V2_Grading & Erosion Control Plan_COMMENTS.pdf Markup Summary

EPC Stormwater- Zachary (28)

ASCENT CHURCH

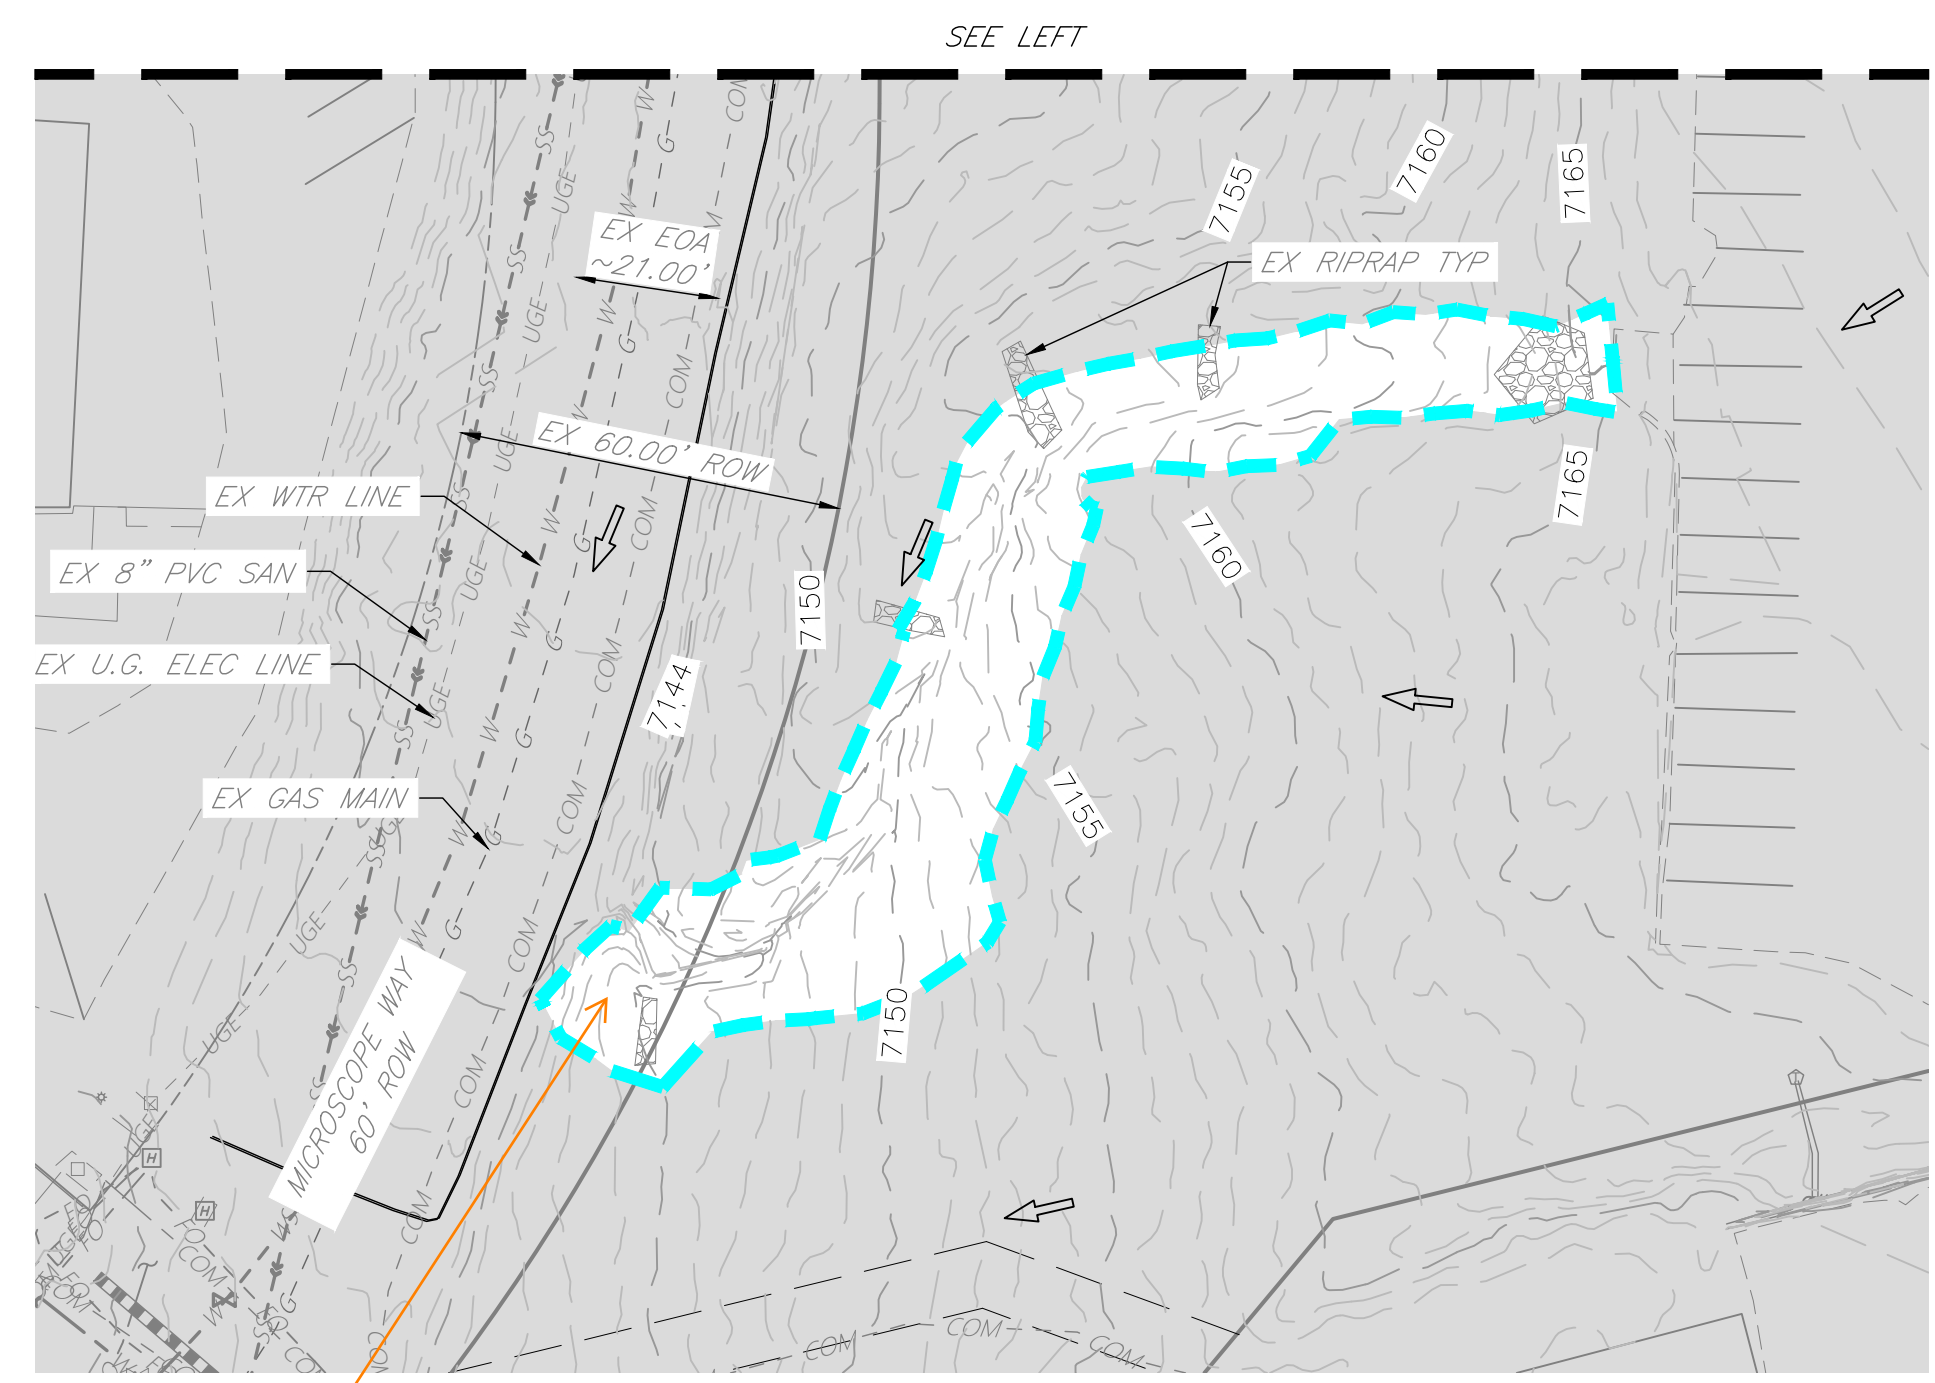
If "limits of disturbance" and "construction boundary" are the same, change to "limits of construction/disturbance" or otherwise show as separate line types for each on the legend and figure.

Show existing vegetation (notes are acceptable in cases where there is no notable vegetation, only grasses/weeds, or site has already been stripped)

Please provide control measures to prevent sediment from discharging off-site during construction

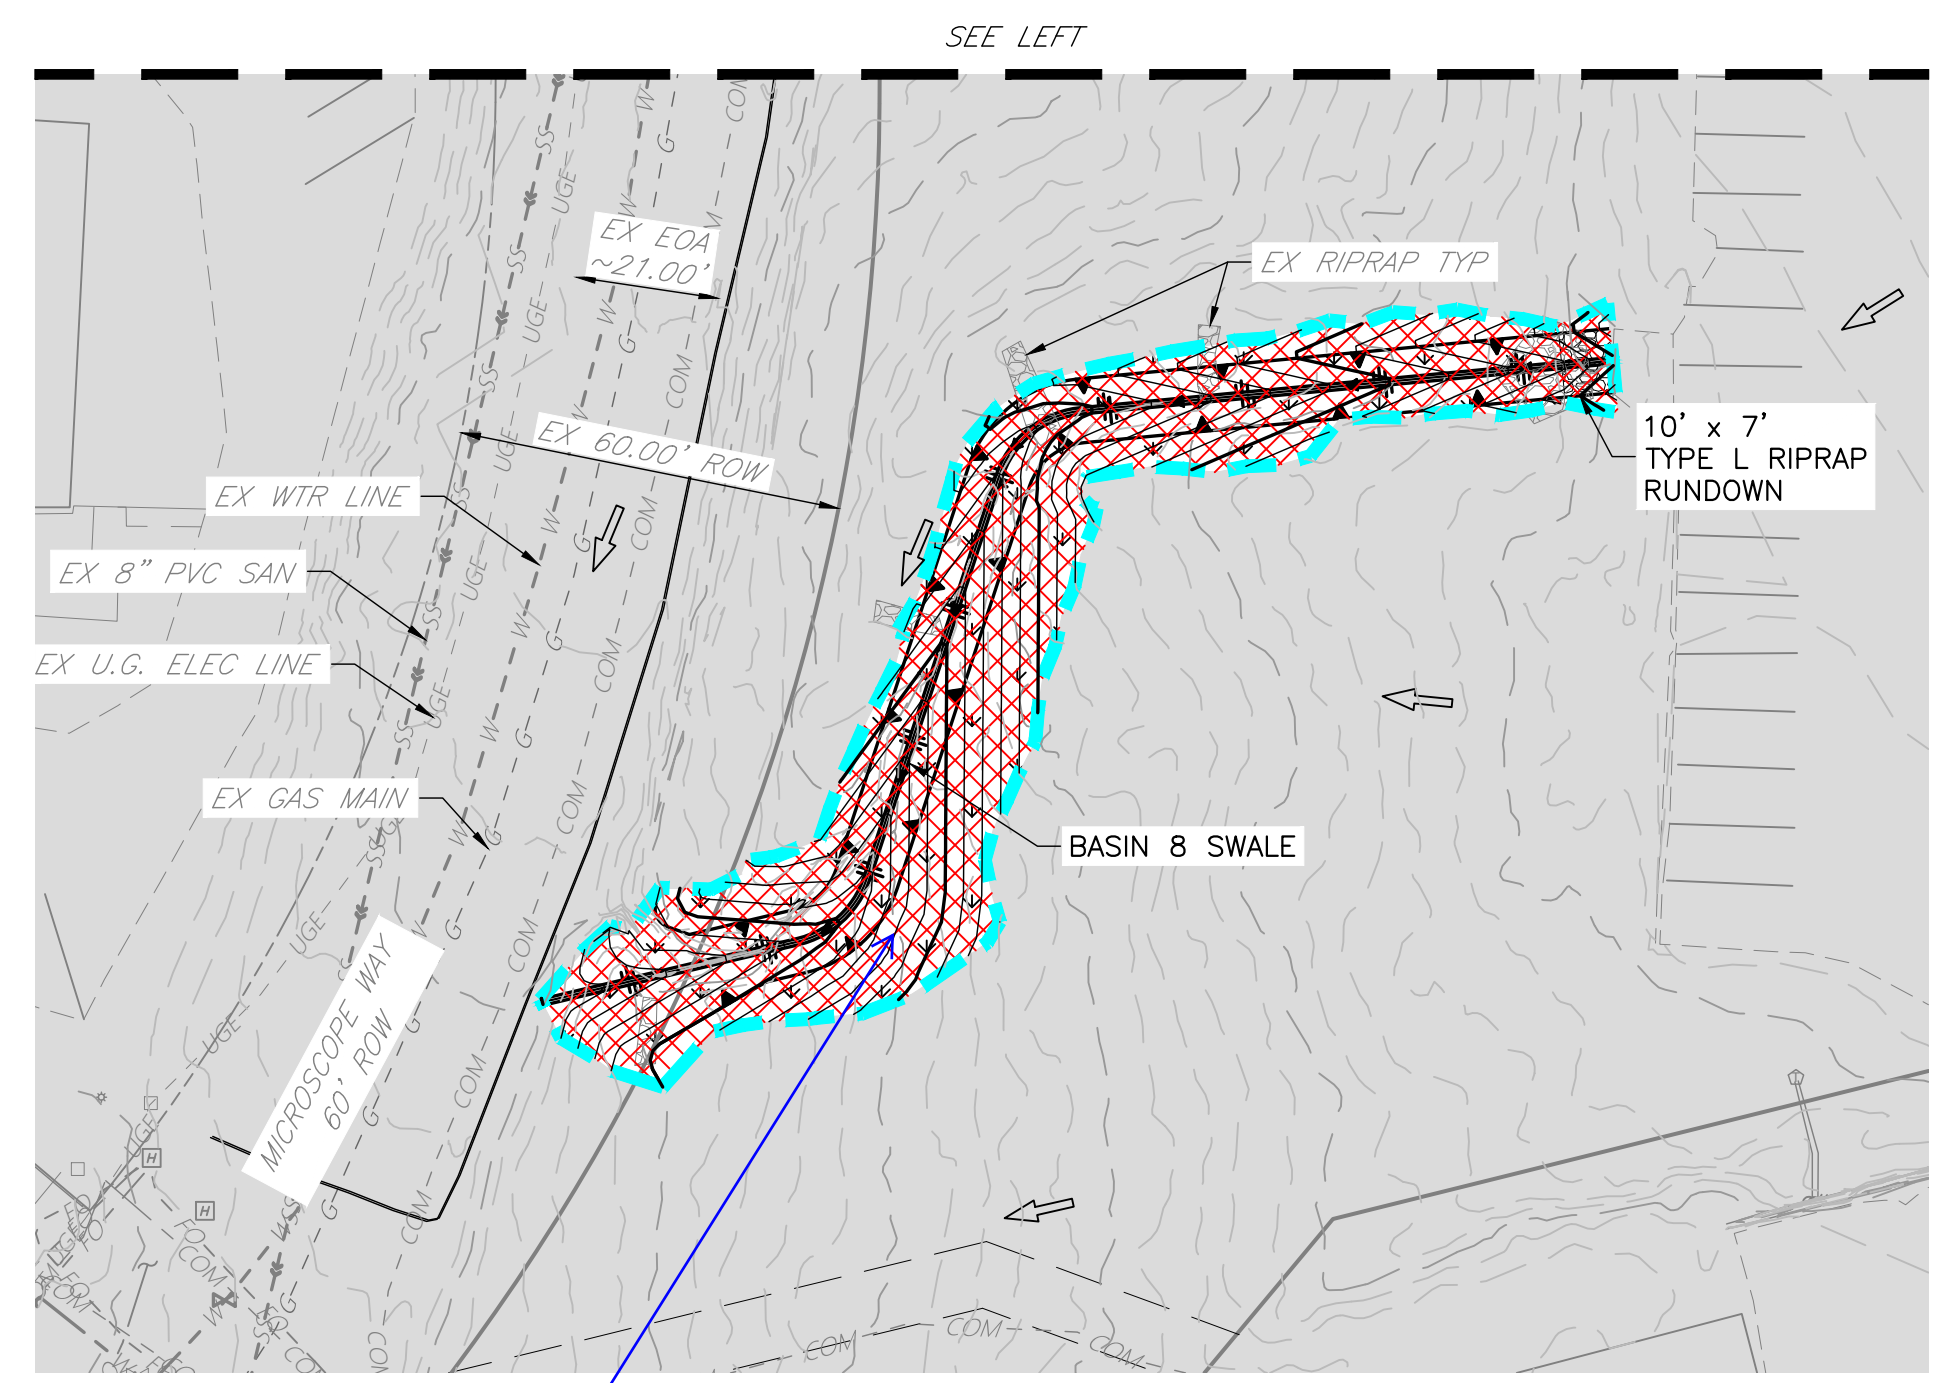
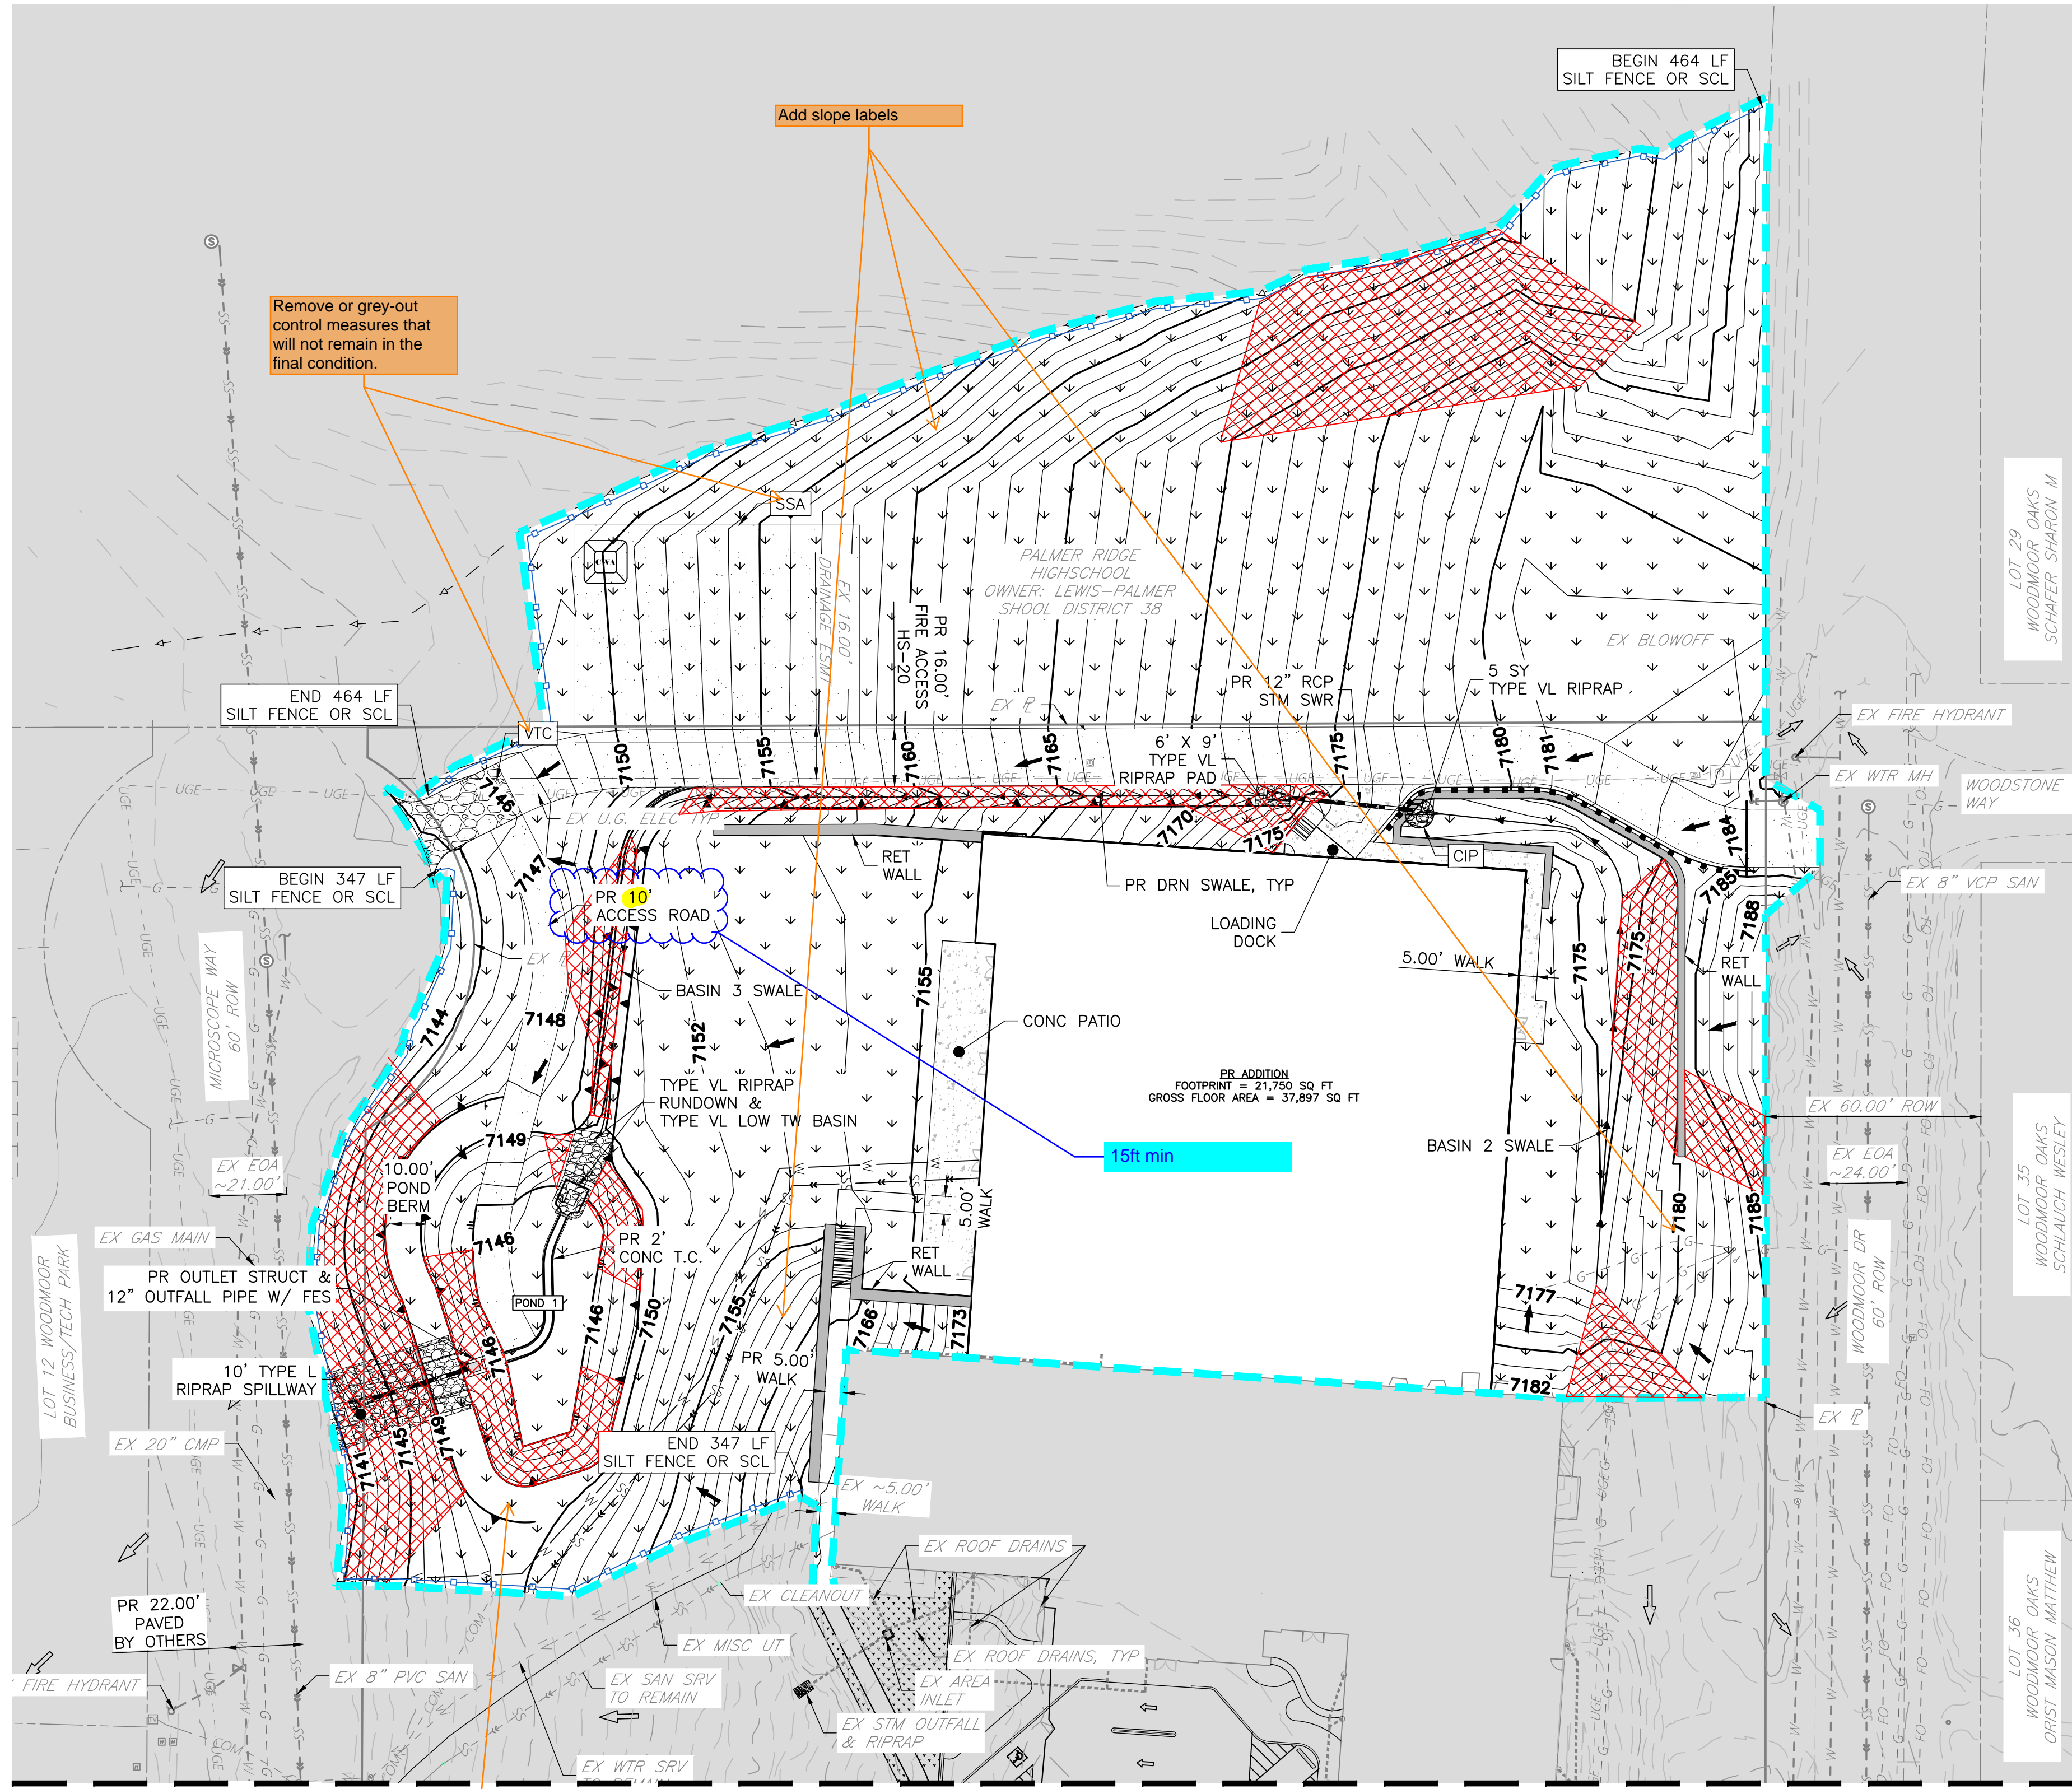
Remove or grey-out control measures that will not remain in the final condition.

Add slope labels

Provide pond maintenance access easement and the road itself from the bottom of the pond up the embankment, around the perimeter of the pond, and to a public road, per DCMv1, Chap 11.2.2.

Indicate the phase of implementation for each temp control measure (initial/interim/final)

Show areas of proposed cut and fill

15ft min

ERB or TRM

Design profile calls out TRM.

If swale will not have irrigation to ensure grass growth then TRM with check dams should be considered. The GEC Plan reflects ECB in the drawing where the swale profile denotes TRM. Velocity exceed 4ft/s such that the seed mix spec'd does not hold and will not establish without irrigation
